**PROPOSED ARROW VALLEY SOLAR PROJECT
PROPOSAL BY ARROW VALLEY SOLAR LIMITED
INFRASTRUCTURE PLANNING (ENVIRONMENTAL IMPACT ASSESSMENT) REGULATIONS
2017 (AS AMENDED) REGULATIONS 10 AND 11**

Thank you for your e-mail of dated 30/03/2026 regarding the information to be provided in an environmental statement relating to the above project.

HSE's land use planning advice:

Project Title	ARROW VALLEY SOLAR AND BATTERY ENERGY STORAGE SYSTEM			
Drawing Title	FIGURE 1.1 SCOPING SCHEME BOUNDARY			
Drawing Number				
Original Size: A3	Scale: 1:70,000	Project Ref: 100125502	Sheet: 1 of 1	Rev: P01

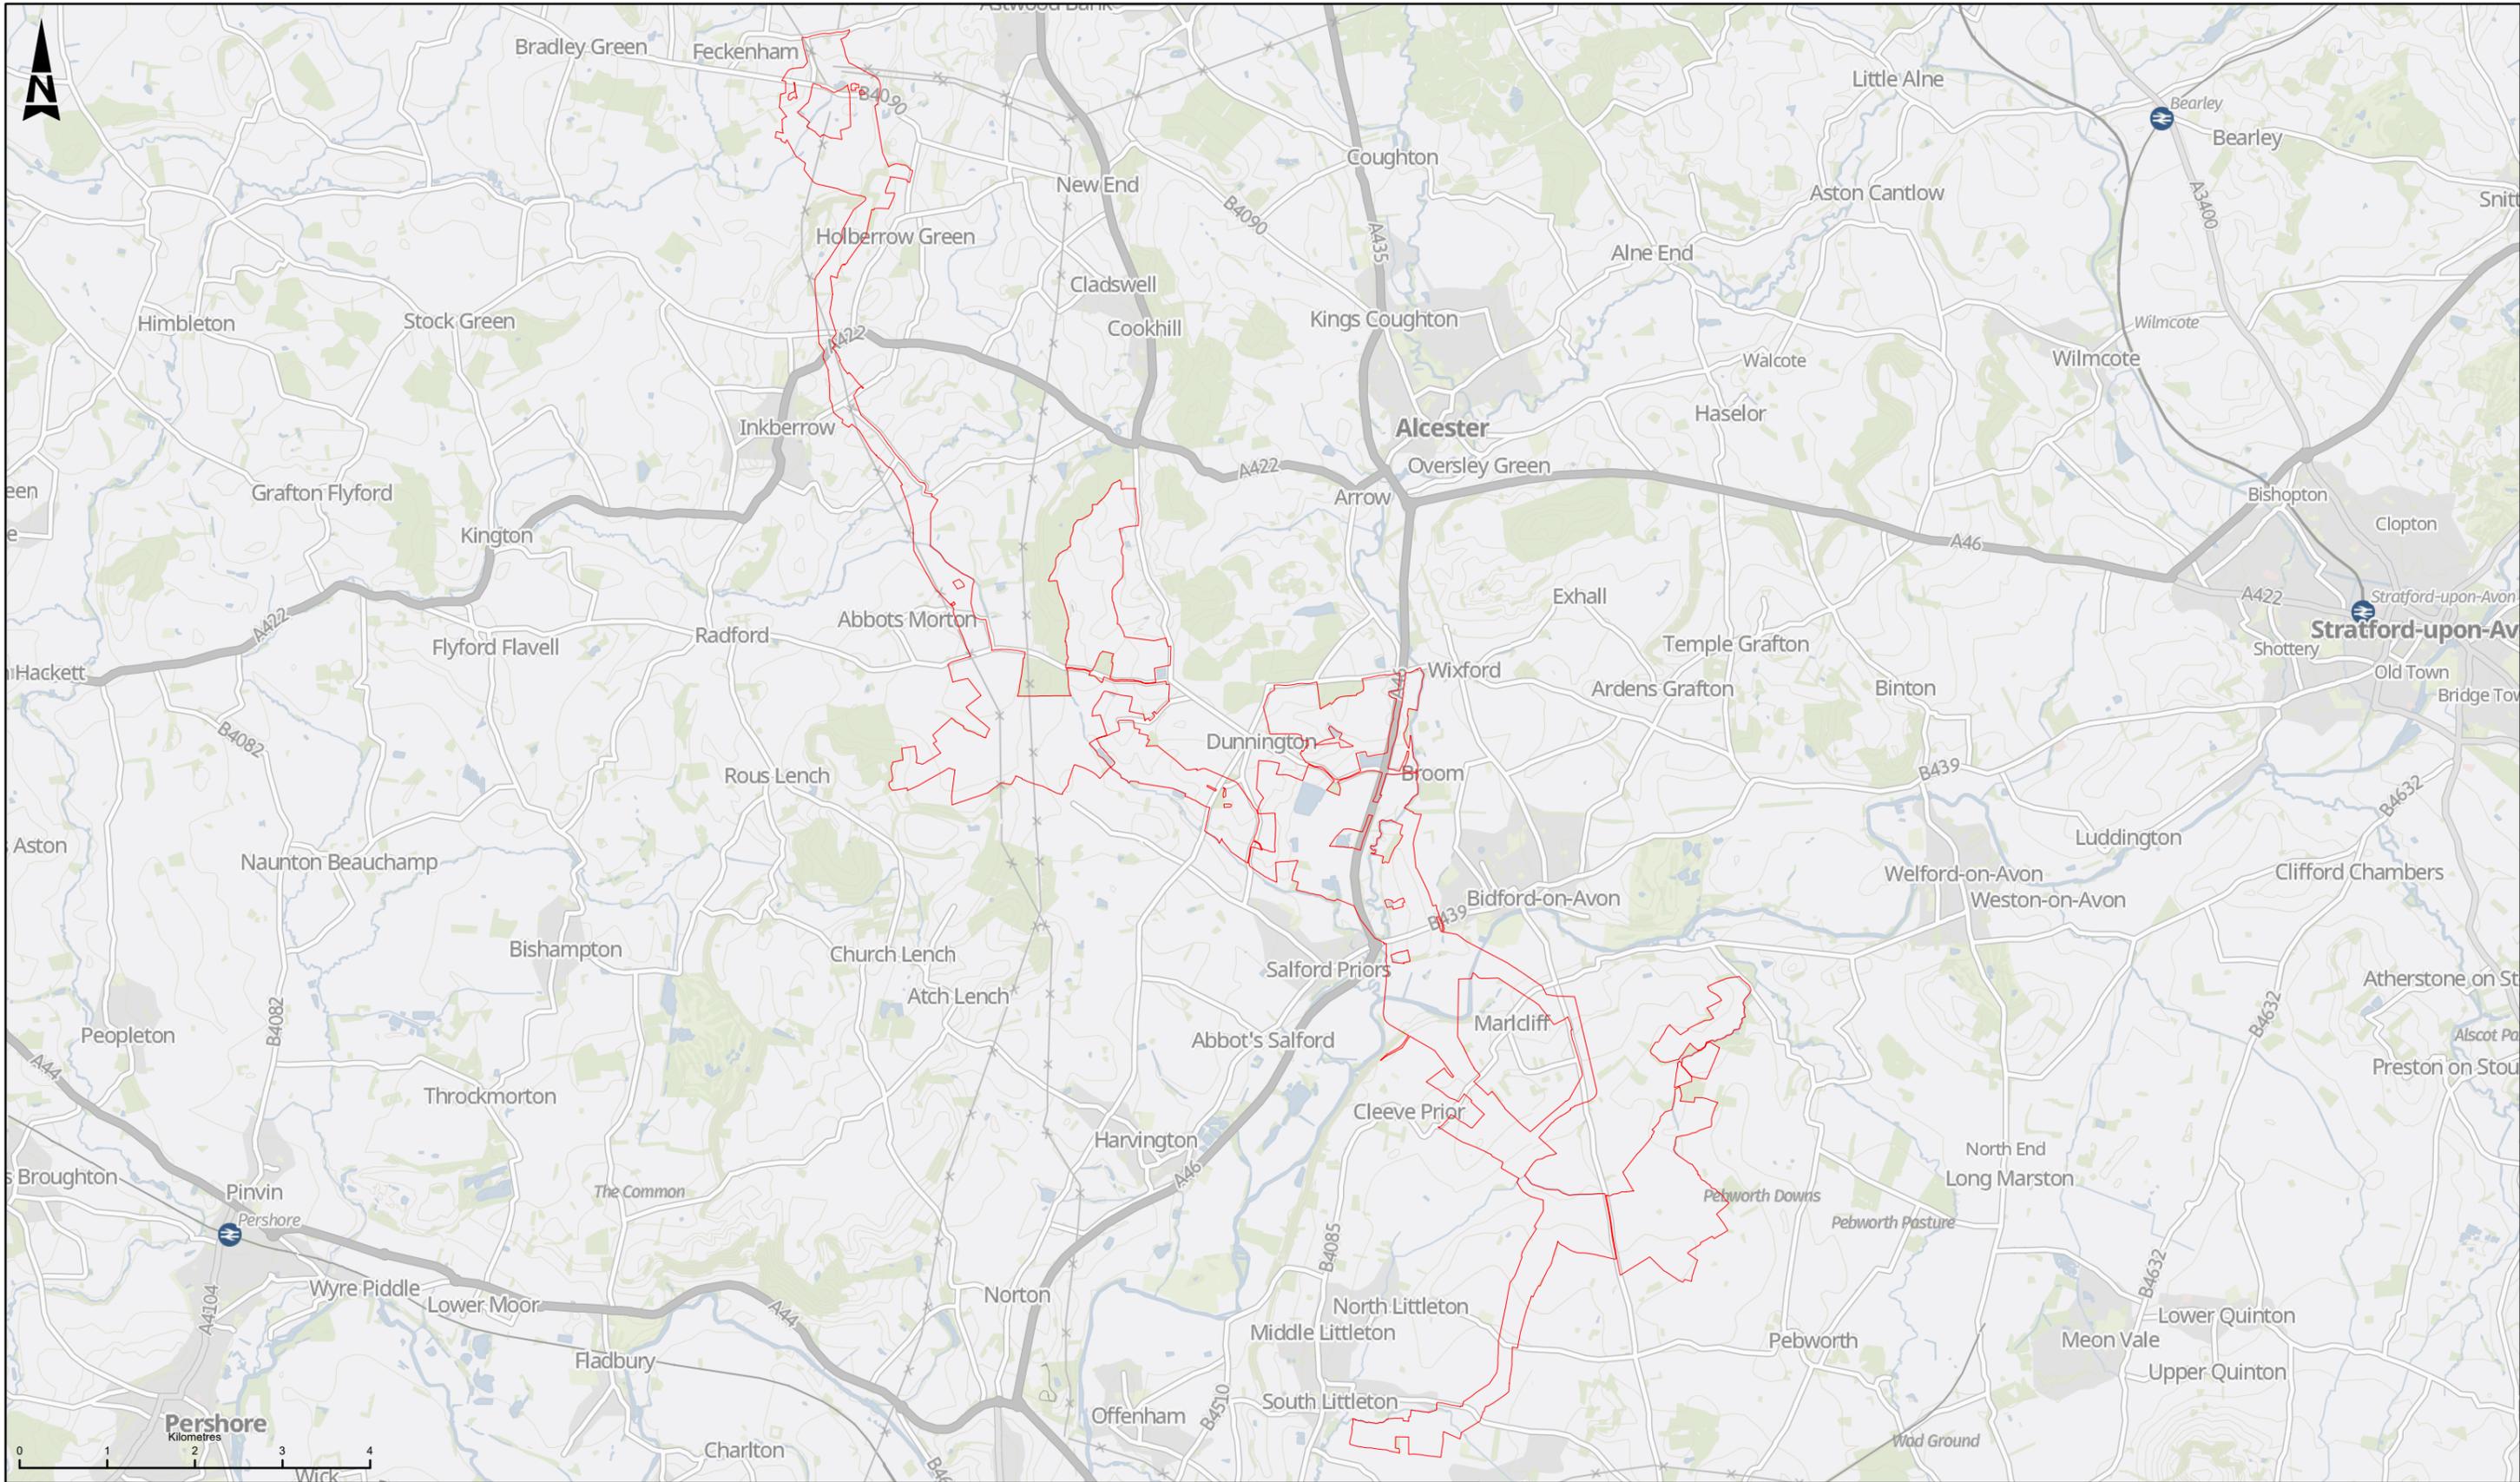
With reference to **Figure 1.1 Scoping Scheme Boundary** found in [<https://national-infrastructure-consenting.planninginspectorate.gov.uk/projects/EN0110033/documents>] on which is shown a red-lined **Scoping Boundary**, sections of the proposed development falls within HSE public safety consultation zones associated with Major Accident Hazard Pipeline:

Rugby/ Hanbury (WM2411) [HSE ref: 4113666, Transco ref:1460] – Cadent Gas Ltd

The red-lined **Scoping Boundary** also falls within the consultation distance of Major Accident Hazard Installation(s):

H2063 – Uk Petroleum Products Ltd (t/a EurogasLtd)

HSE will not advise against the proposed development, providing no population(s), either temporary or permanent, is introduced within any of HSE's public safety zones nor would HSE advise against Workplaces (DT1.1 - Workplaces)*, providing for less than 100 occupants in each building and less than 3 occupied storeys.
